Recommendation Report for Planning Permission for Works or Extension to a Dwelling

REF NO: LU/196/15/HH

LOCATION: 13 Blakehurst Way
Littlehampton

PROPOSAL: Extension/Alteration. This application may be determined by Littlehampton Town Council under delegated powers

SOUTH (front) 1/100

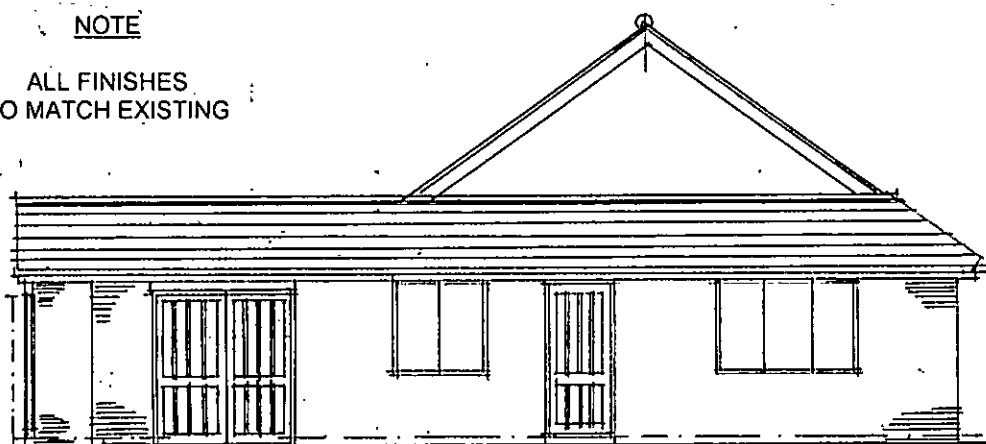
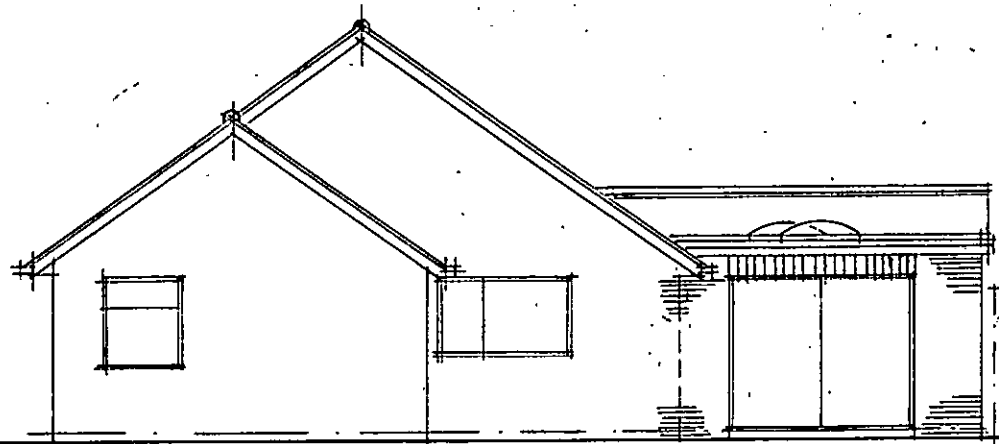
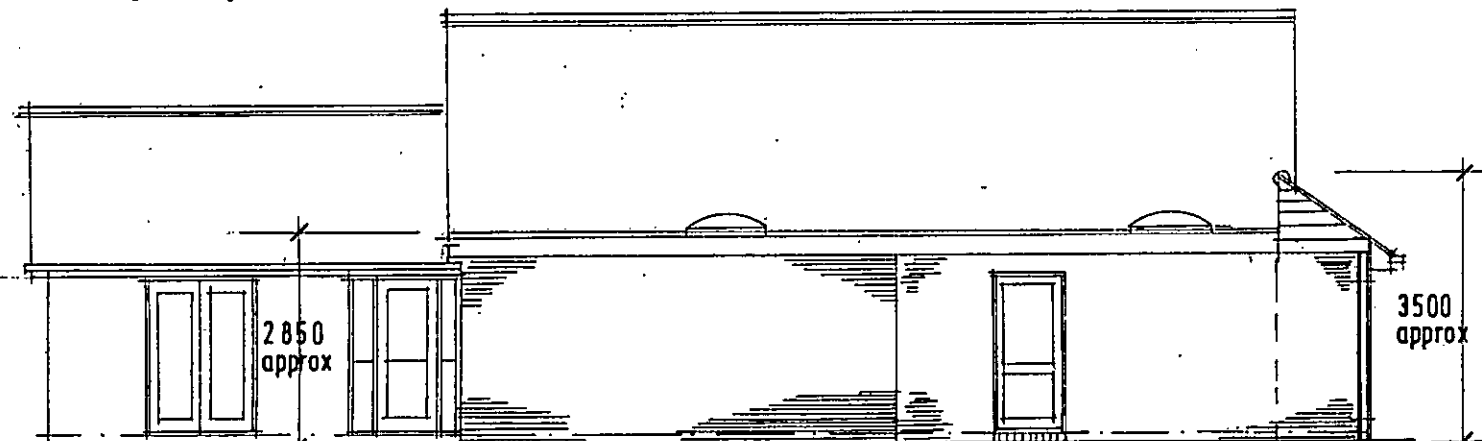
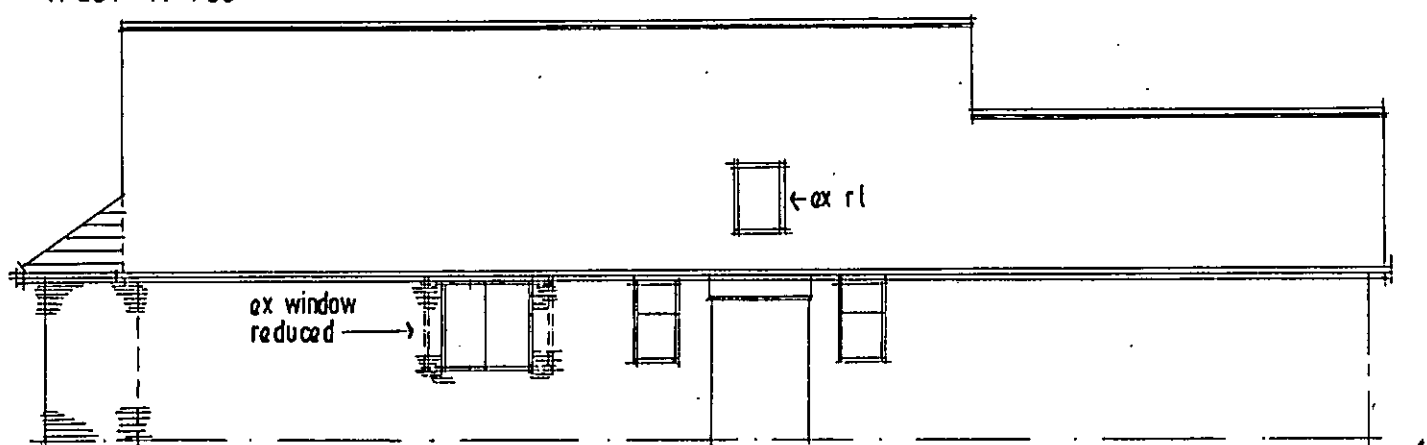
The application seeks permission for the construction of a single storey front extension which will extend 1.2 metres beyond the forward elevation of the property. The proposed front extension will feature a mono pitched roof and will be constructed from materials which match in appearance those used in the construction of the original dwellinghouse. Therefore, due to this and the proposed size and scale of the front extension it is considered to be subservient and well integrated with the host dwelling and as such is considered to be in accordance with policies GEN7 (ii) and DEV19 (i) & (ii) of the Arun District Local Plan.

Front extensions have the potential to negatively impact upon the established character and spatial pattern of the street scene. However in this instance, the proposal by virtue of its design, is not considered to have any such adverse impacts. The orientation of the host dwelling ensures that the proposal does not appear overly dominant within the street scene. Therefore, the proposed front extension is considered to be in accordance with policy DEV19 (v) of the Arun District Local Plan.

The proposed front extension is not considered to give rise to any overbearing, overshadowing or overlooking impacts upon the residential amenity of neighbouring properties and is therefore considered to be in accordance with policies GEN7 (iv) and DEV19 (iii) of the Arun District Local Plan.

FLOOR PLAN 1/100

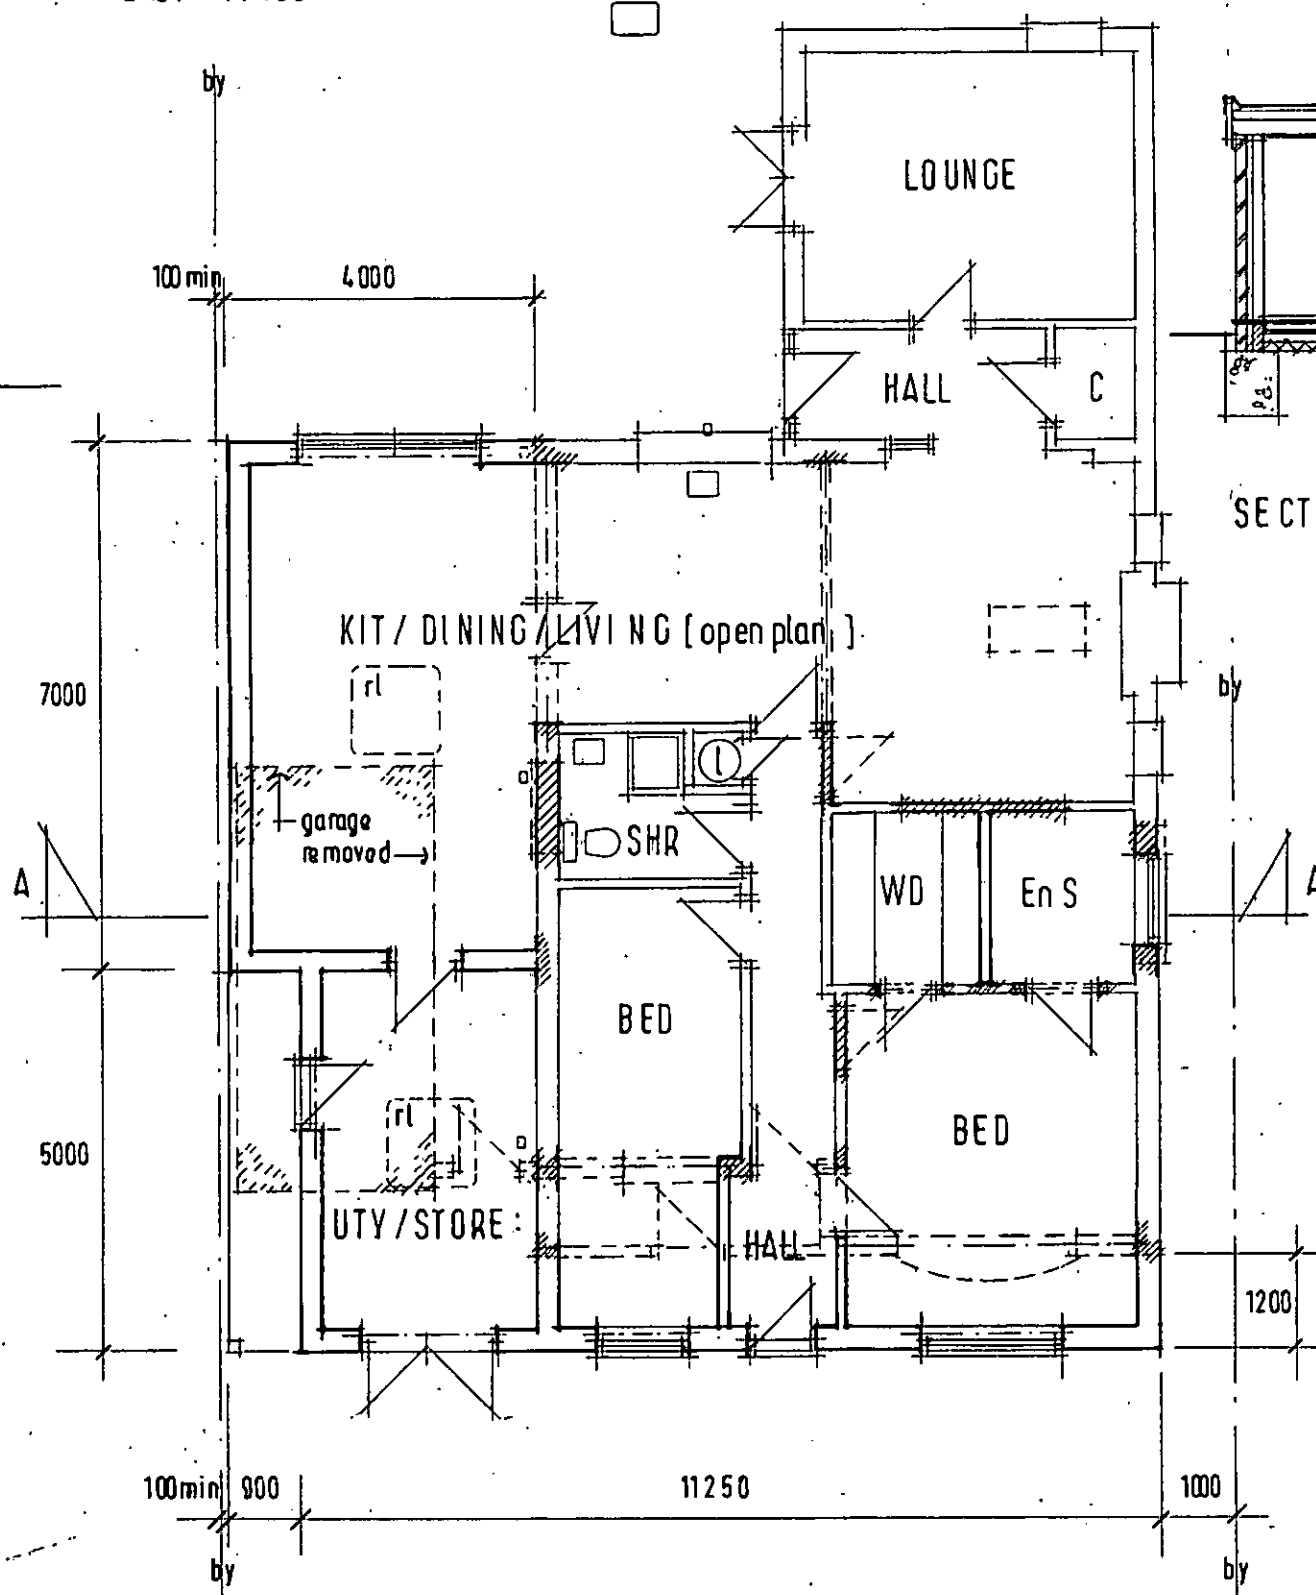
The proposed single storey side extension will extend 4 metres to the side of the original

dwellinghouse and measure 2.7 metres in height. The proposed side extension by virtue of its design and appearance is considered to be subservient and well integrated with the host dwelling in accordance with policies GEN7 (ii) and DEV19 (i) & (ii) of the Arun District Local Plan.

The proposed side extension will be located 0.1 metres from the southern boundary of the site, the same distance as the existing detached garage present on the site. The proposal will be an additional 6.4 metres in length in comparison to the existing garage. The property to the south of the application site is located 8 metres from this boundary with the height of the single storey extension at 2.7m it is considered to not give rise to any adverse overlooking, overshadowing or overbearing impacts. As such, it is considered to be in accordance with policies GEN7 (iv) and DEV19 (iii) of the Arun District Local Plan.

The proposal will result in the loss of the garage and as such some parking provision on the site. However, the application site is considered to retain adequate parking provision to ensure that this will not have any unacceptably adverse impacts upon residential amenity.
